Sunningdale
West Drive
Angmering
BN16 4JE

Planning Department
Arun Civic Centre
Maltravers Road
Littlehampton
BN17 5LF.

Objection to Arun District Council Planning application: A/121/17/HH

<table><tr><td>PROJECT HARDCOURT West Drive, Angmering Littlehampton. BN16 4JE</td><td rowspan="4"> 29 Breach Avenue, Southbourne, Emsworth, Hampshire. PO10 8NB T: 01243 697164 M: 07879471666 www.pdkconsulting.co.uk</td><td rowspan="4"> PDK Architecture and Surveying</td></tr><tr><td colspan="2">DRAWING PROPOSED SITE PLAN</td></tr></table>

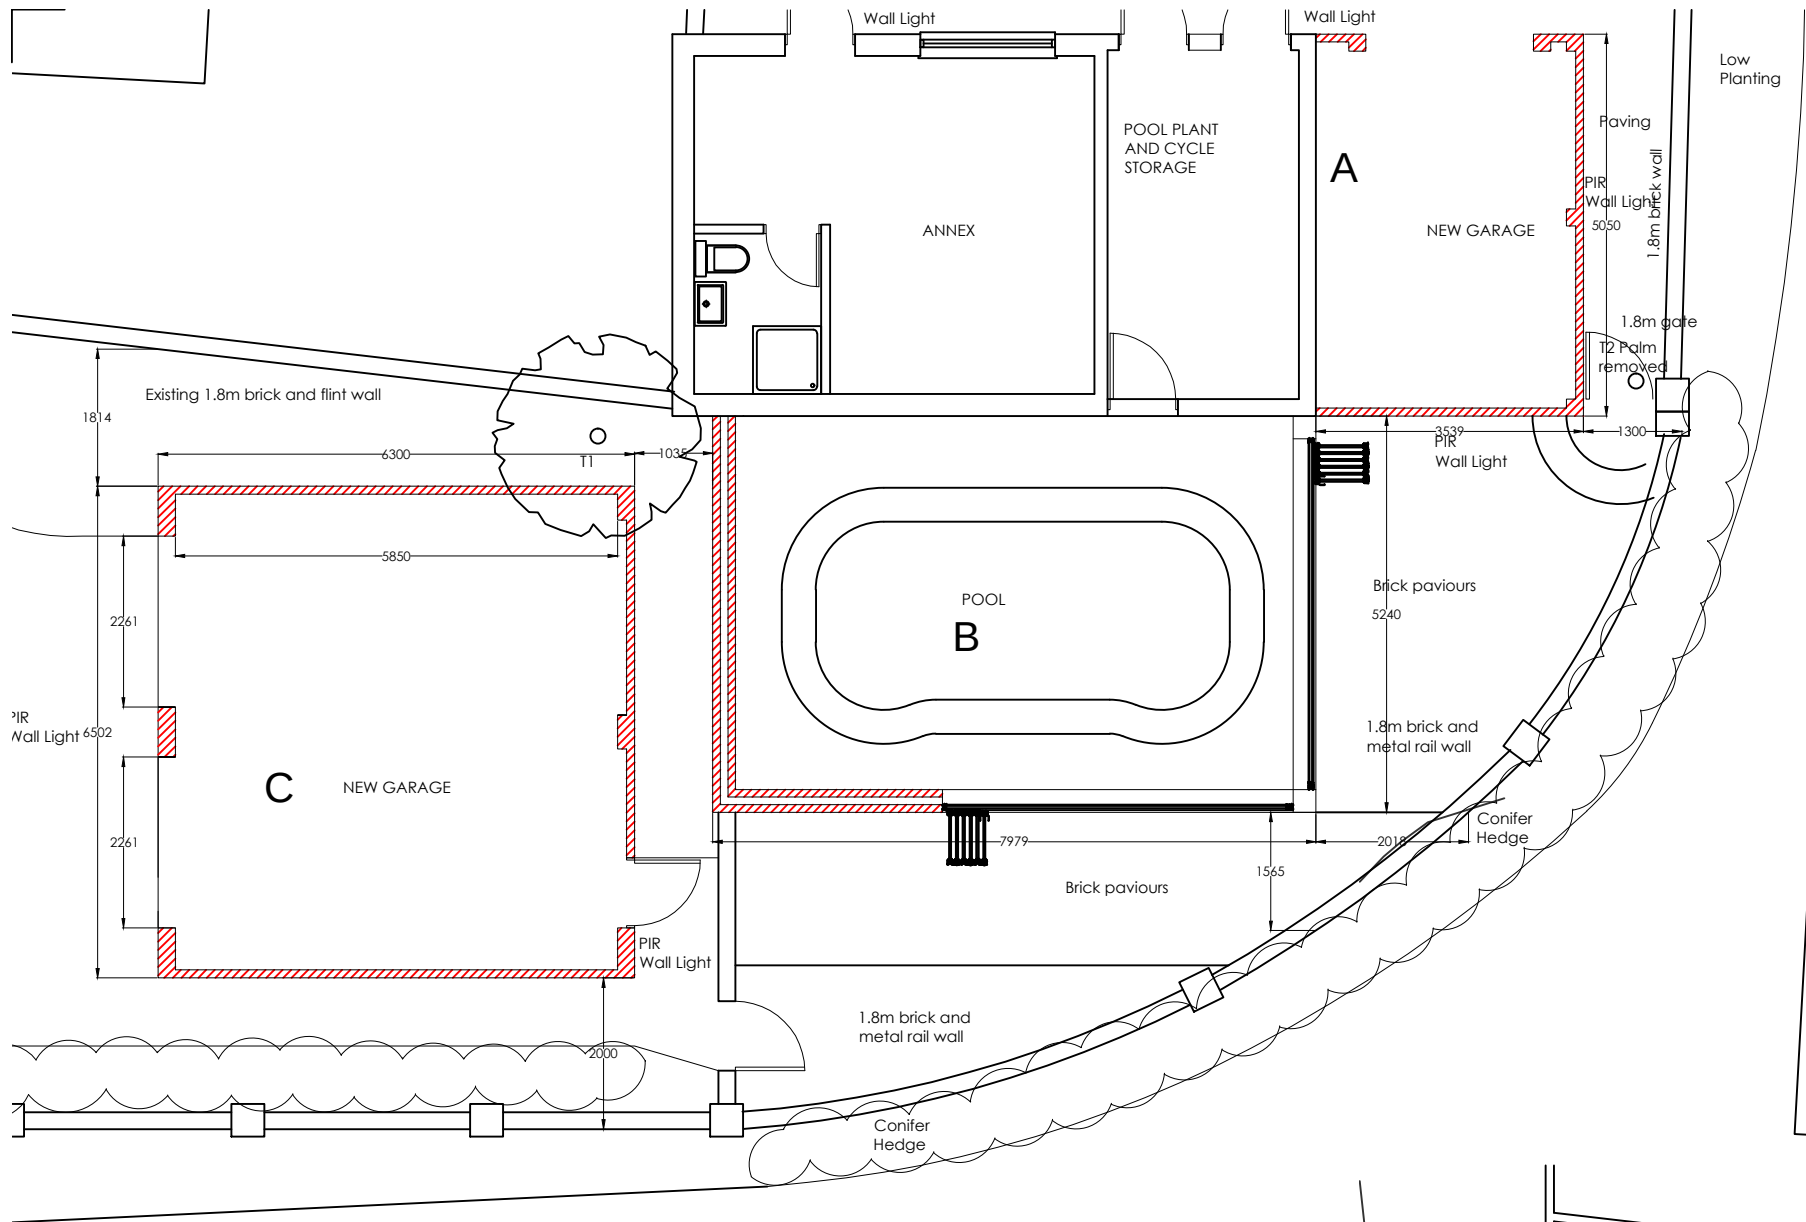
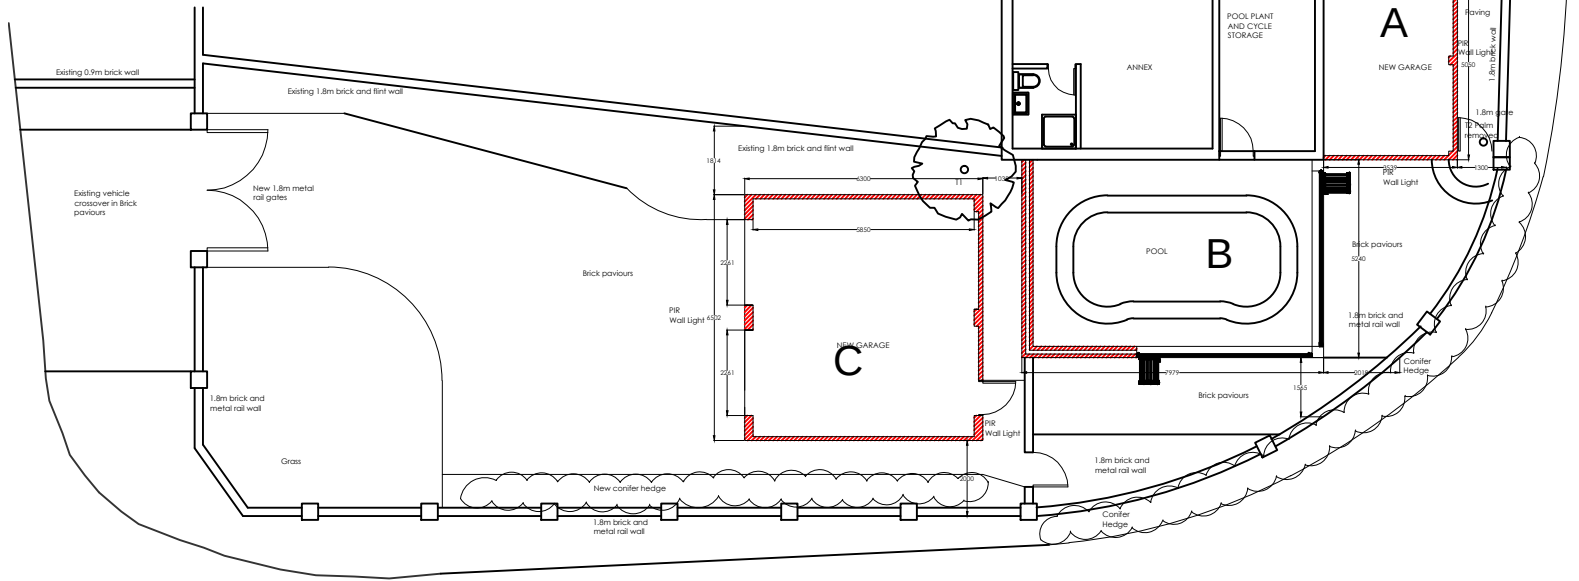
9. While the drawings accompanying the application show a perimeter wall 1.8meters in height it does not show clearly that the brick element averages only approximately 63cms with the remainder wide spaced iron railings between brick pillars. The erection of tall entrance gates and introduction of hedging will only serve to further reduce the appearance of openness in this area.

10. The proposed access point for this site is on a corner of two roads and where sight lines are at best, poor. The roads are narrow, busy with relatively fast moving traffic and include a public footpath which is actively used. The point of egress from this plot carries potential danger and will expose other road users to risk, particularly with proposed additional hedging further obscuring vision.

11. The proposed construction of the double garage on the plot at its highest elevation will necessitate major excavation works and earth removal to create a level area for construction, posing a significant threat of disturbing the foundations of my property, which sits immediately adjacent and at a much higher elevation. This will be further exacerbated through the excavation and earth removal required along the remainder of the western side of the parcel to create the level surface for access and parking.

12. Construction and hard surfacing of this lawn area will eliminate its capacity to act as natural drainage/soak away for the much higher land to its west, increasing the risk of surface water flooding to West Drive, the lowest point, by overwhelming existing drainage arrangements. The made Angmering Neighbourhood Plan **EH3** requires that new development '...must ensure that it does not increase the flooding impact it may

PROPOSED ELEVATIONS NEW DOUBLE GARAGE

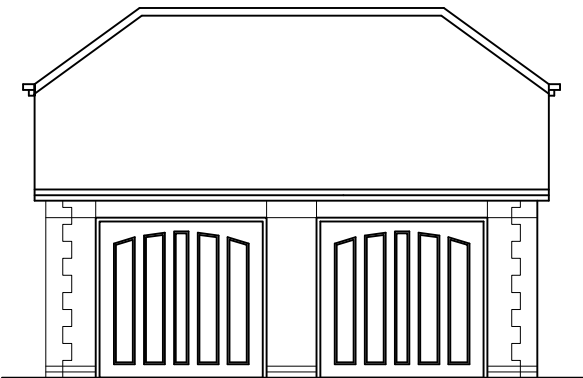
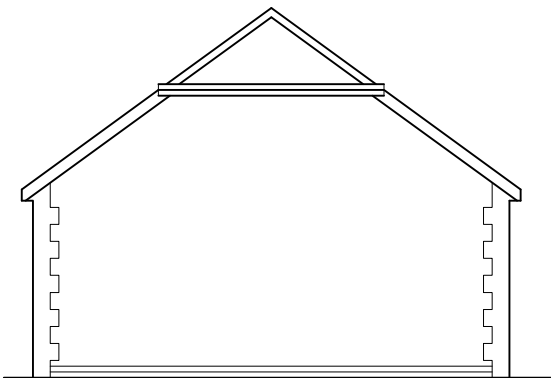
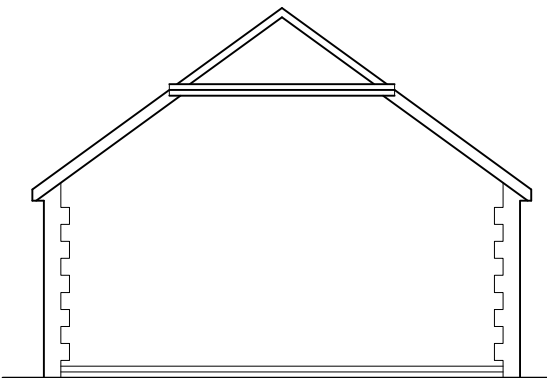
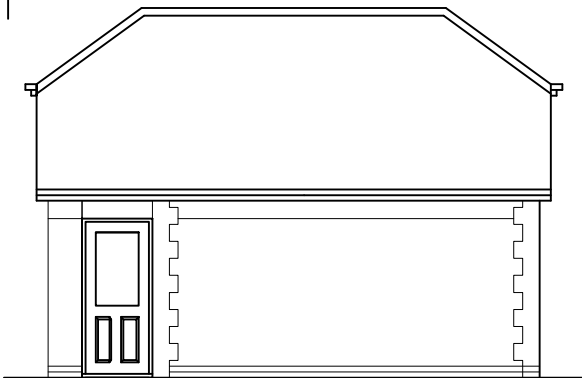
7. The construction of the double garage will have a direct detrimental impact on my property through loss of amenity through the apparent height of the structure creating shadow and loss of openness, which is identified and readily acknowledged in the planning application, but without identifying the exact height of the structure.

8. As noted The height of the proposed structure does not appear to be indicated, but from the drawings and given the extent of excavation that will be necessary to create a level area, it appears disproportionately tall, carrying the potential for development by stealth, with conversion of the roof area into a mezzanine for other purposes at a later date.
